November 09, 2023

Re: Farolito Senior Community - Mixed-use Multifamily

Is responding to DFT comments dated October 18th, 2023. DFT comments are shown in **Red**
and Responses are shown in **Orange**.

SHEET NO: SDP 1.1

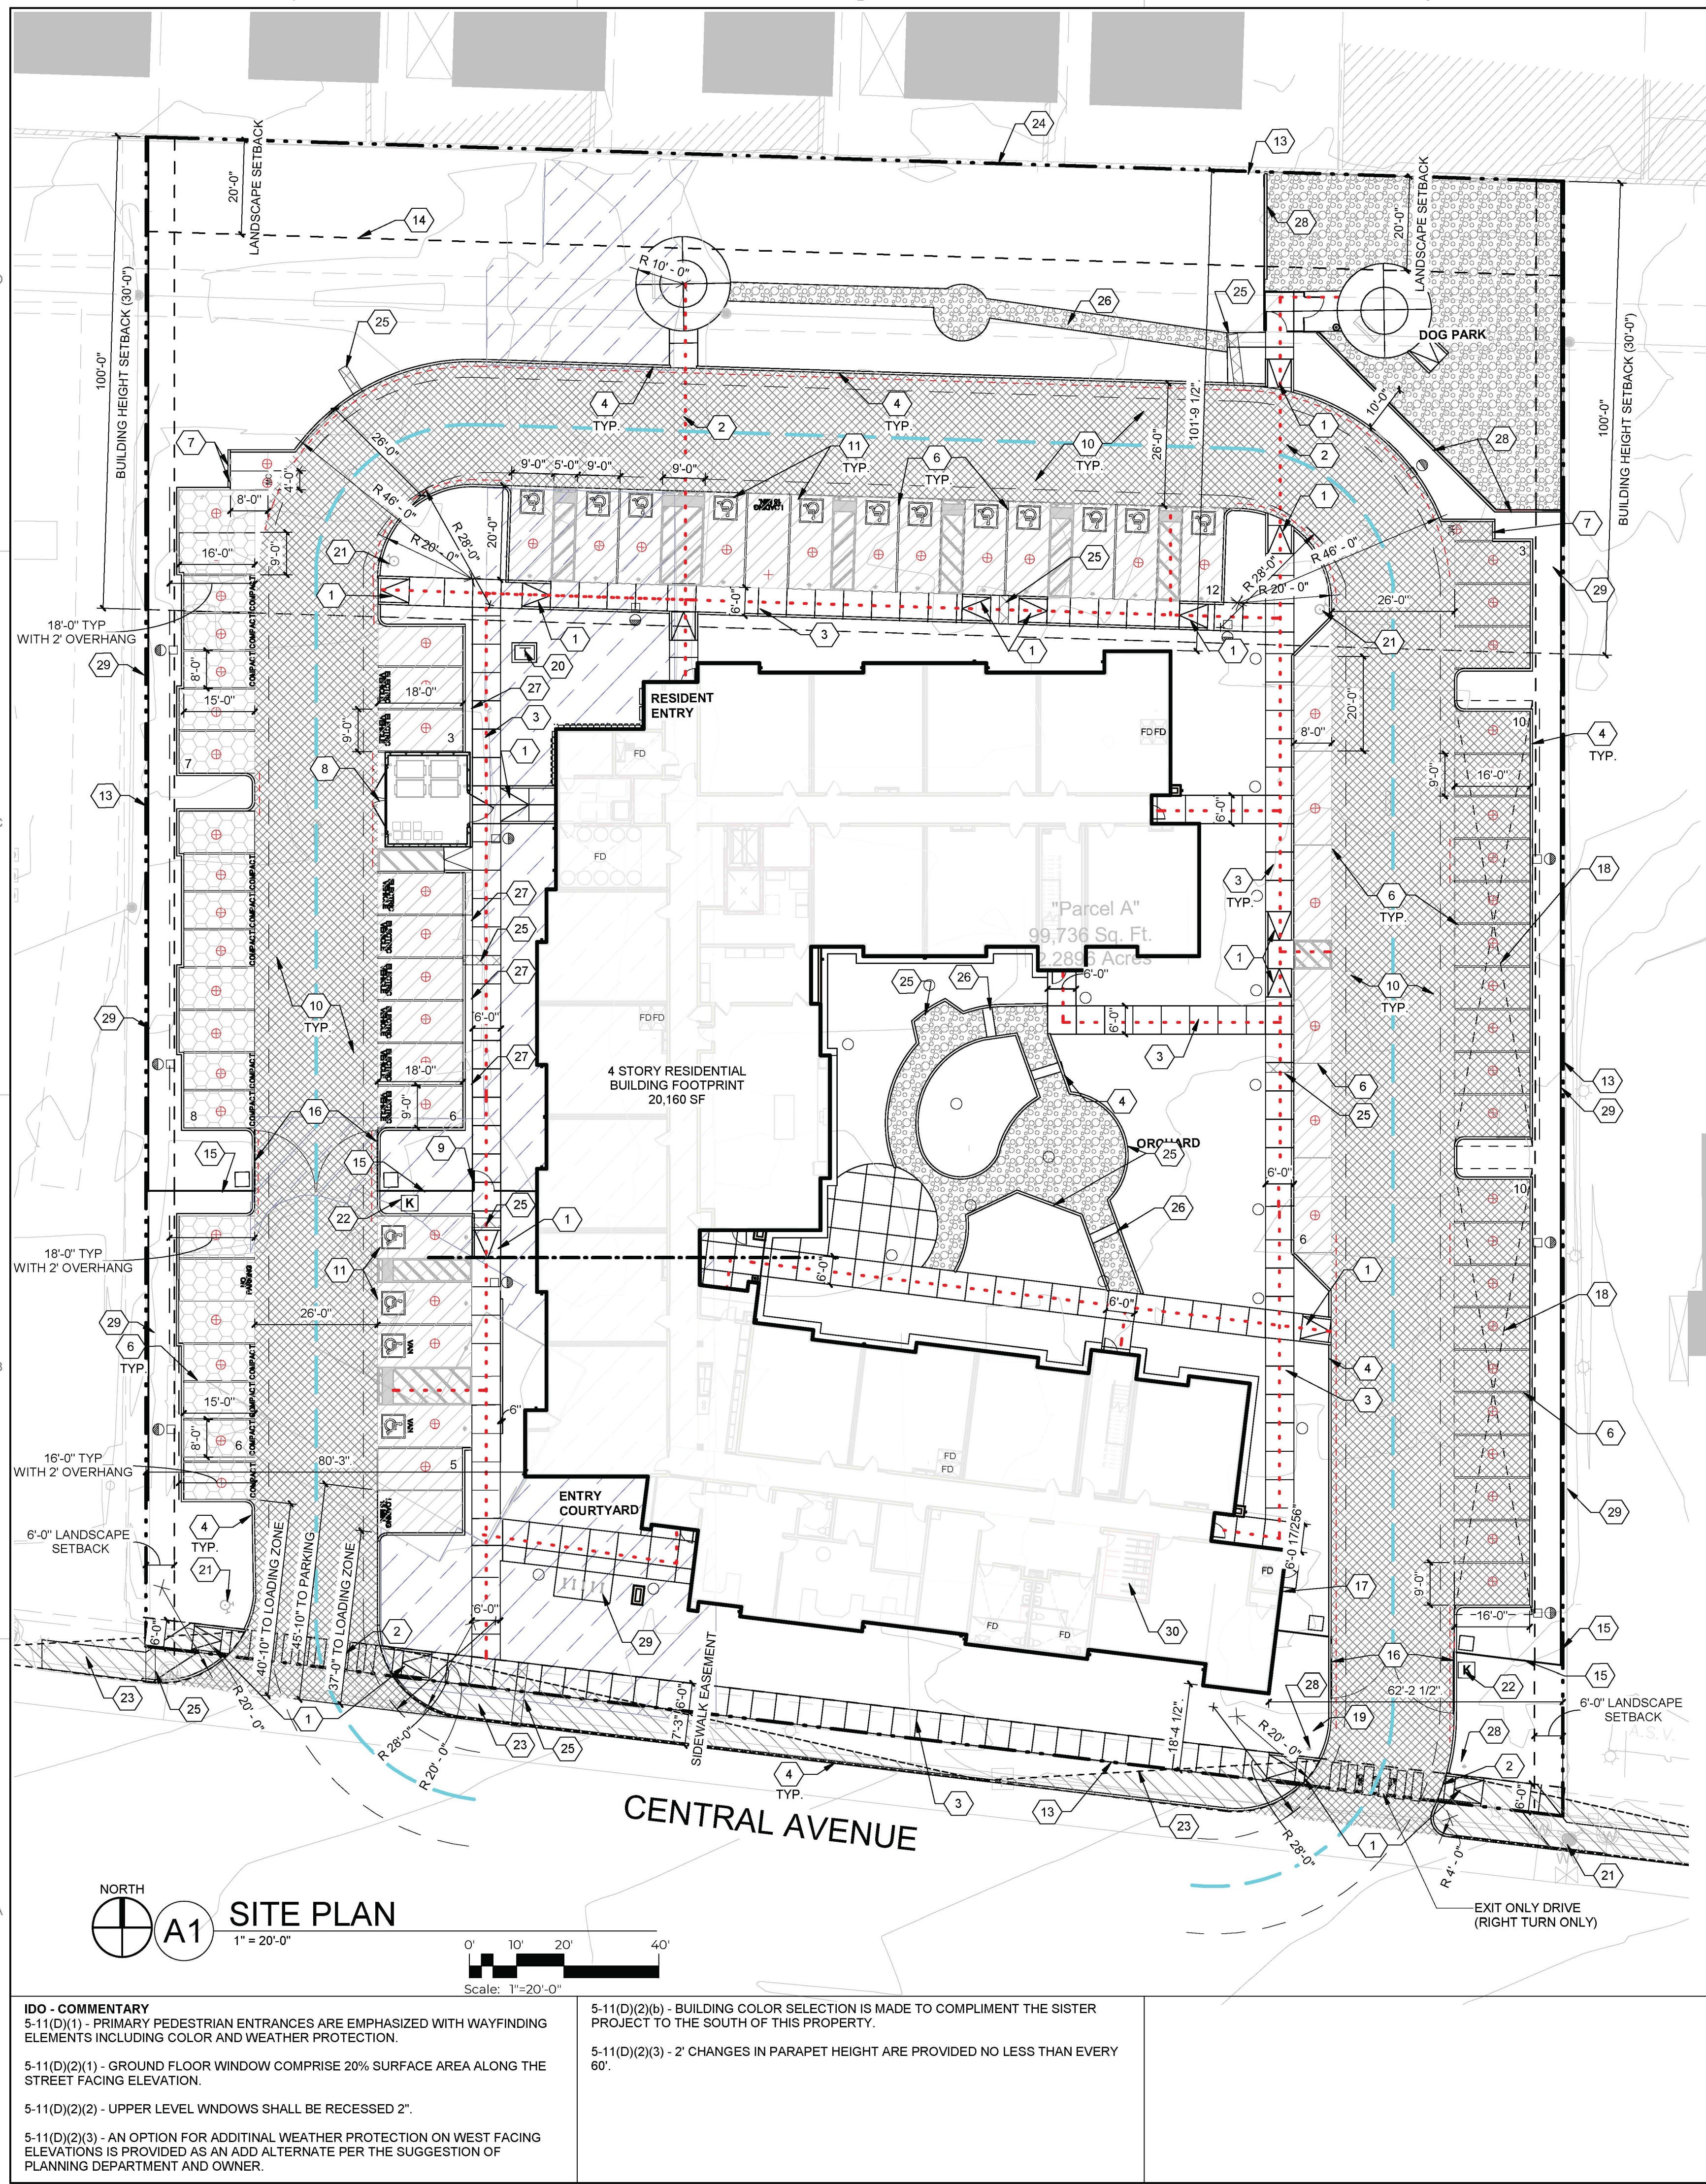
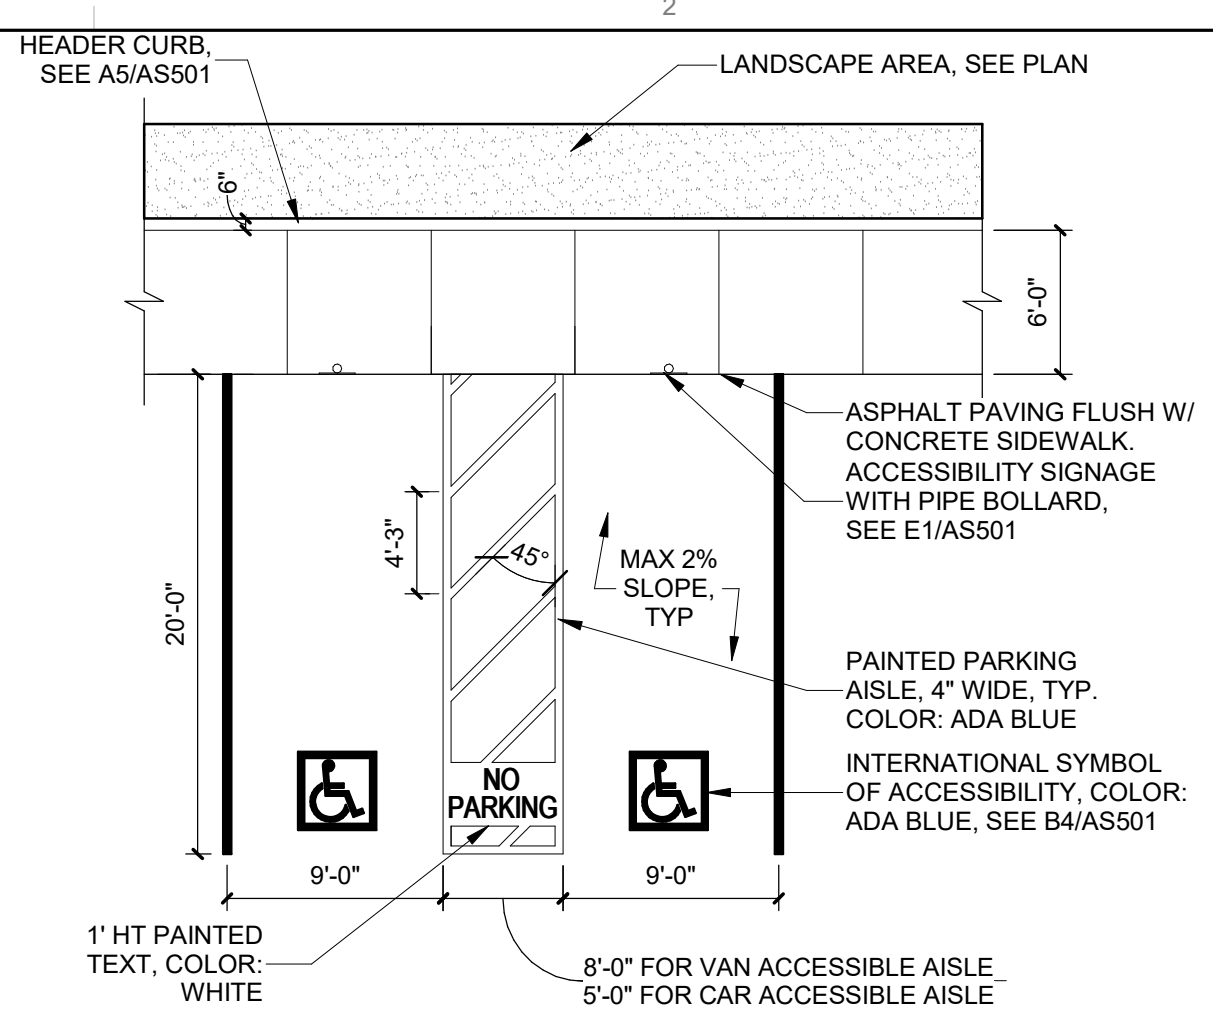
- **Project and application numbers must be added to the site plan set.** Project & application numbers have been included on sheet SDP1.1

- Per 5-1(D) Mixed-Use Zone Districts, all development in any Mixed-use zone district shall comply with the dimensional standards in Table 5-1-2. Minimum Usable Open Space required: 1-bedroom units: 72 x 225 sq.ft.=16,200 sq.ft.2-bedroom units: 10 x 285 = 2,850sq.ft. Total minimum required Open Space= 19,050 sq.ft. **Include the provided Usable Open Space on your calculation table.** Usable open space has been added to SDP1.1 (38,052 sf. Provided)

A1 PLANTING PLAN
1" = 20'-0"

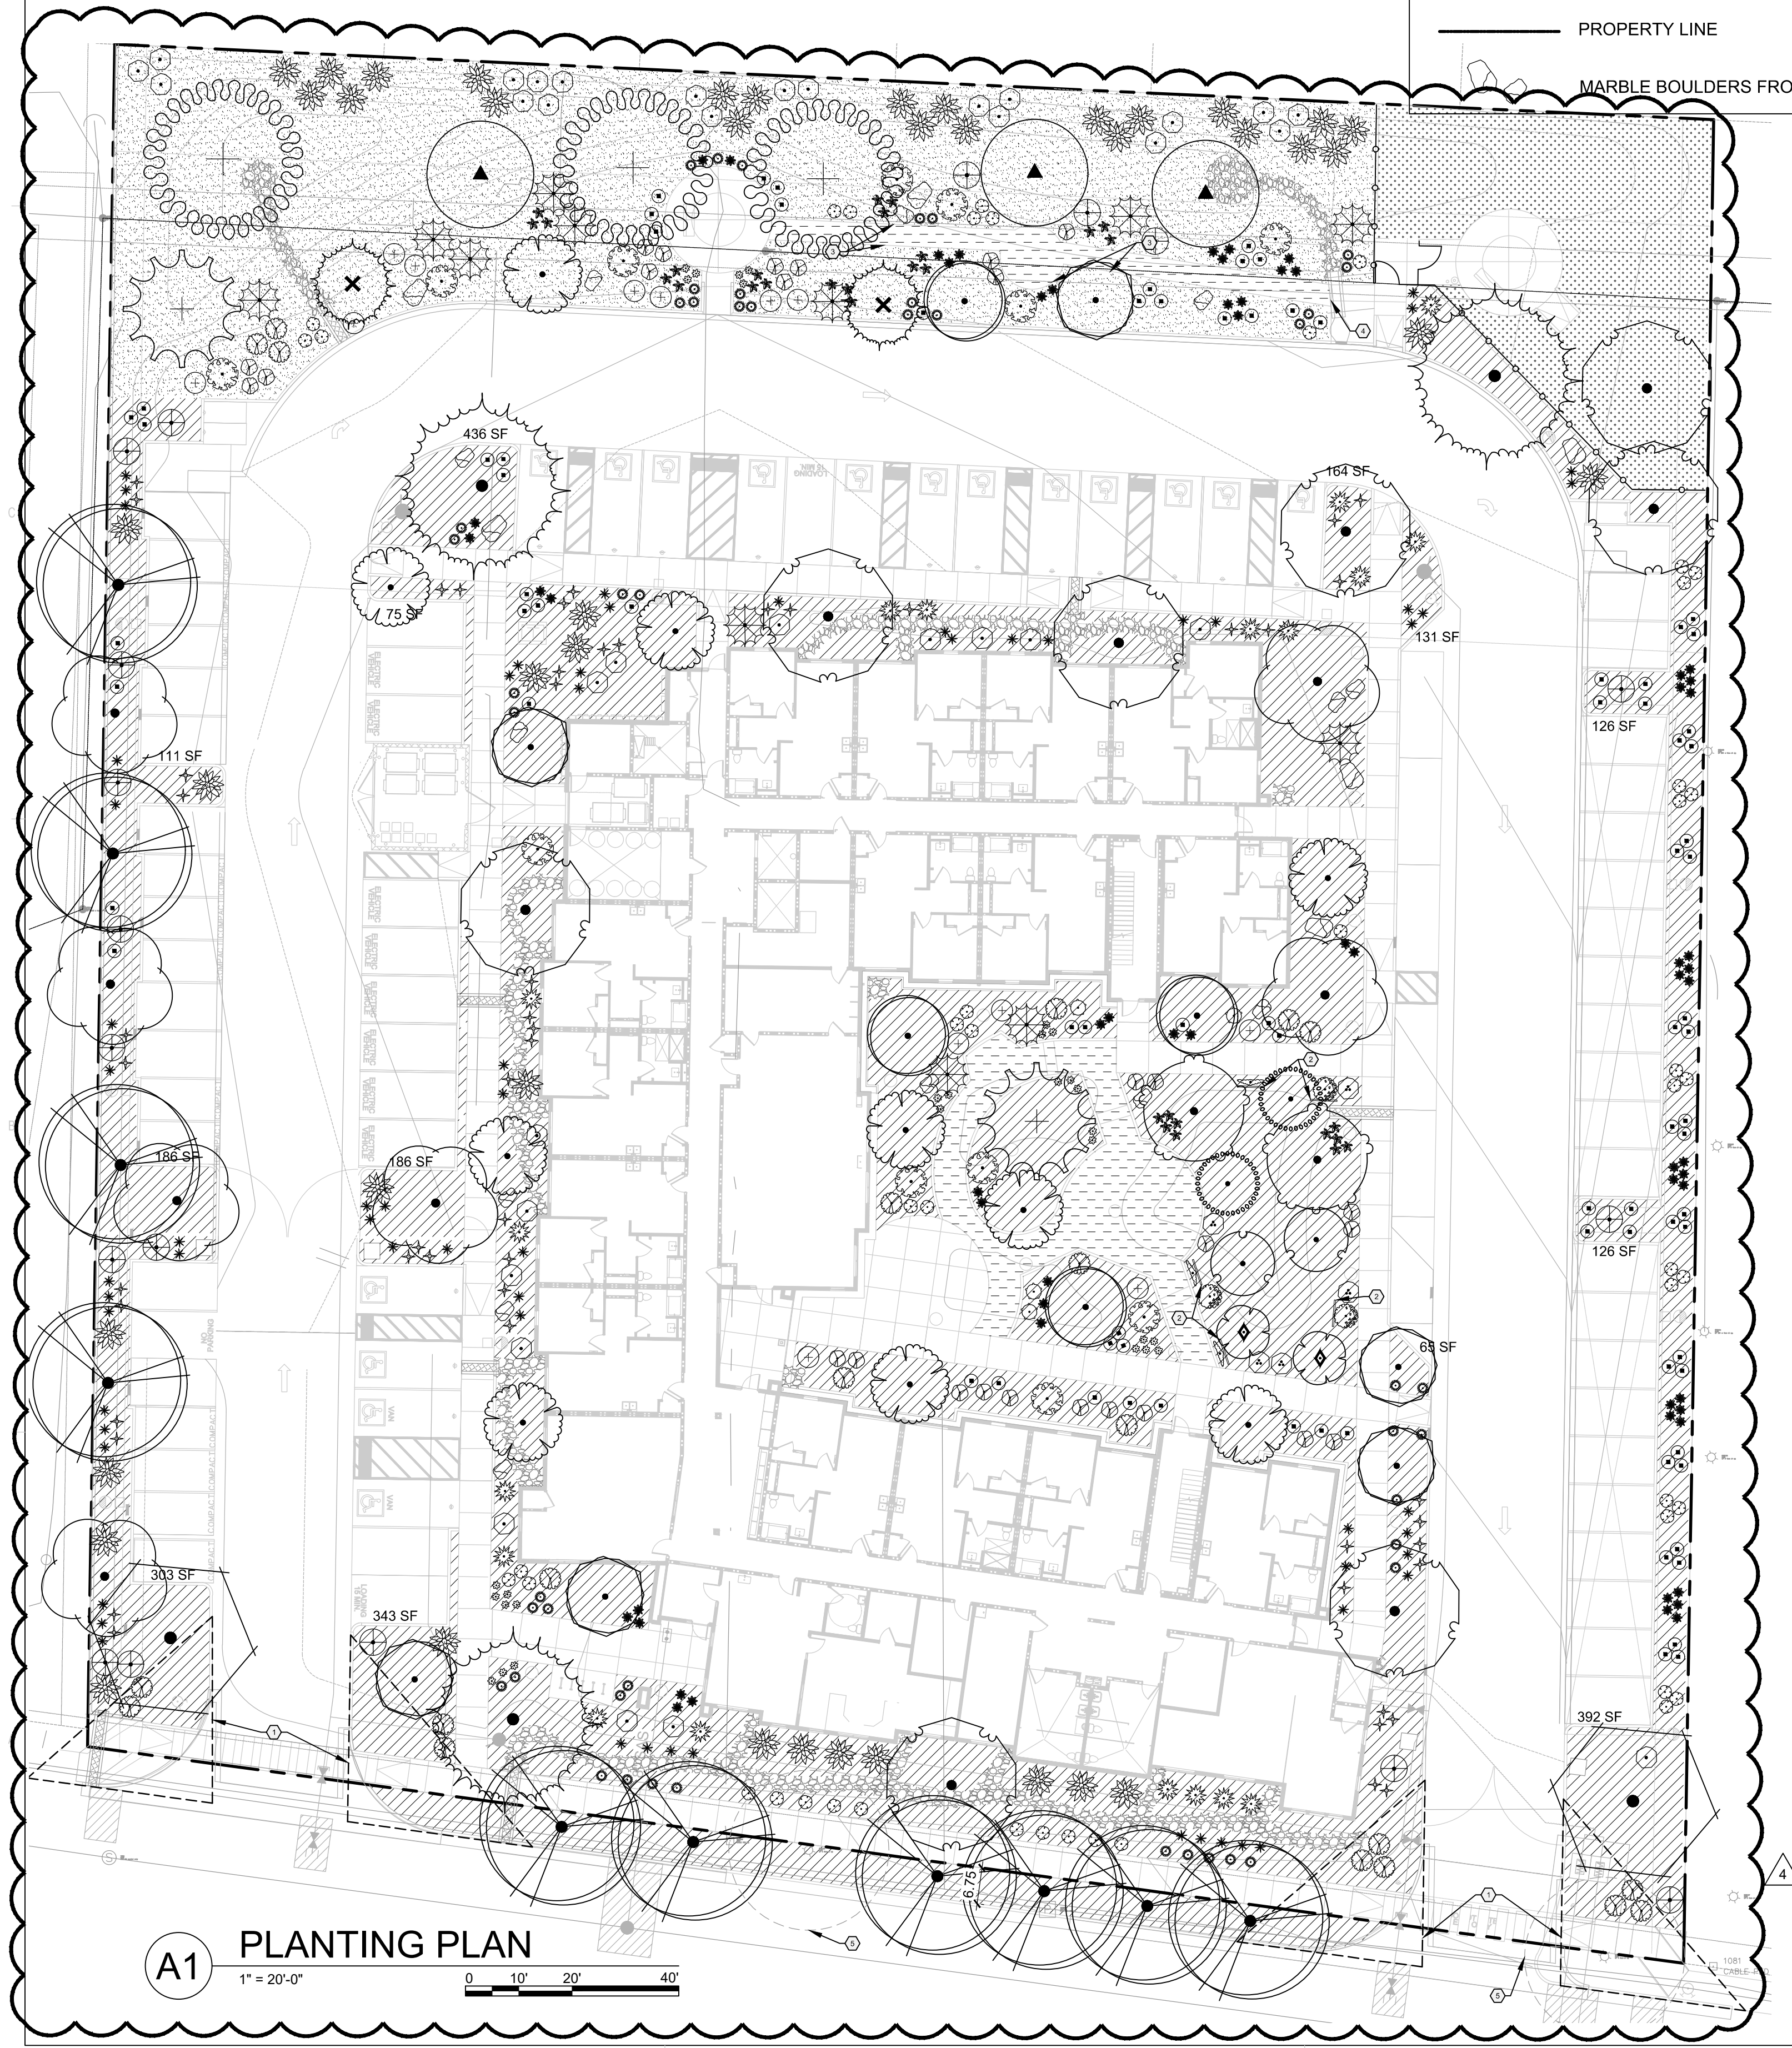
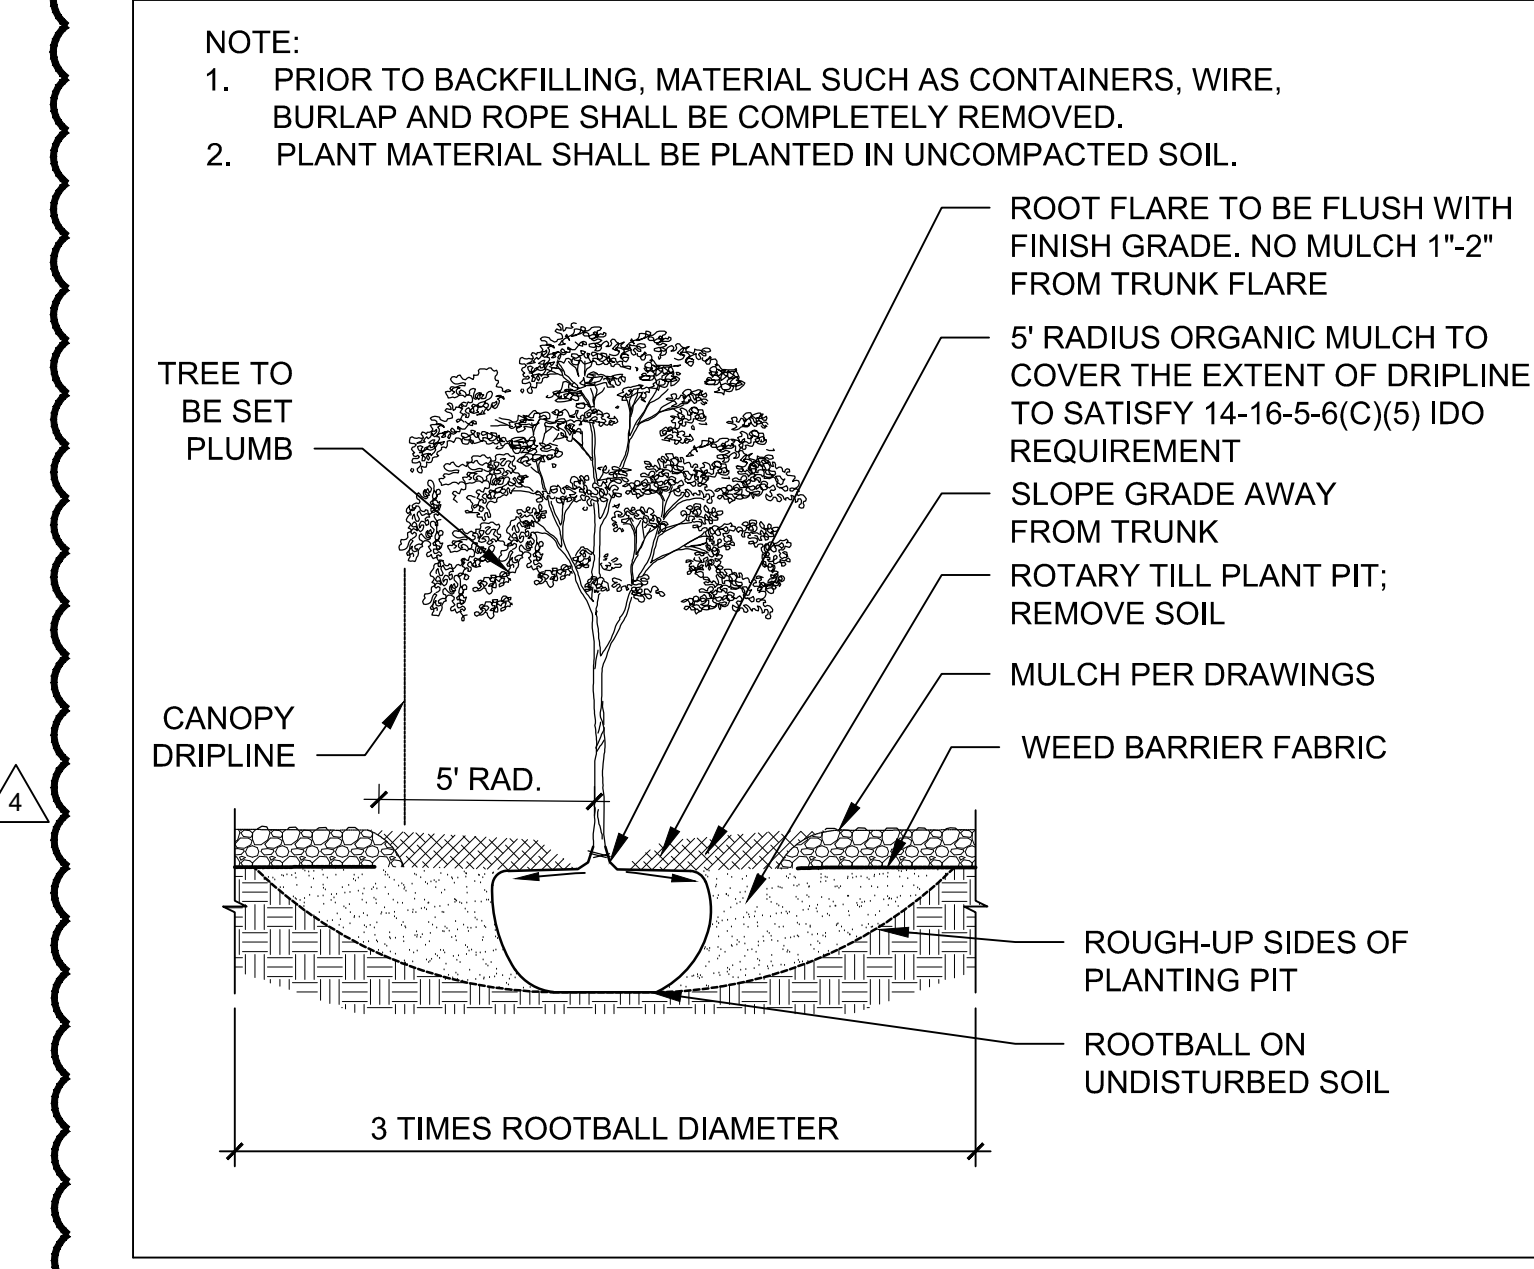
- 4-3(B)(8)(c) 1. At least one tree per ground floor dwelling unit and 1 tree per second floor unit. **Articulate how the design meets this criterion.** One tree per ground and second floor have been provided for this site. Total tree counts can be found on Landscape calculations LP101.

- Per 5-6 (C)(2)(c) tree canopies and ground level plants shall cover a minimum of 75 percent of the total landscape area as measured by canopy width or the area beneath the dripline of mature size of actual vegetation. Required vegetative coverage is the minimum of 26,240 sq. ft. The provided vegetative coverage is 40,312 SQ. ft. Please include mature sizes of the plant material on your plant legend. This is covered in the new LP501, DFT Sheet.

- Per 5-6(C)(5)(e) Organic mulch is required as ground cover under trees within a 5-foot radius around the tree trunk, but not directly against the trunk. In these areas, weed barrier fabric is prohibited. Please correct tree planting detail to show a 5-foot radius bark mulch around the tree trunk. Please remove the weed barrier extension from this 5-foot radius area. Please see below. Corrected.
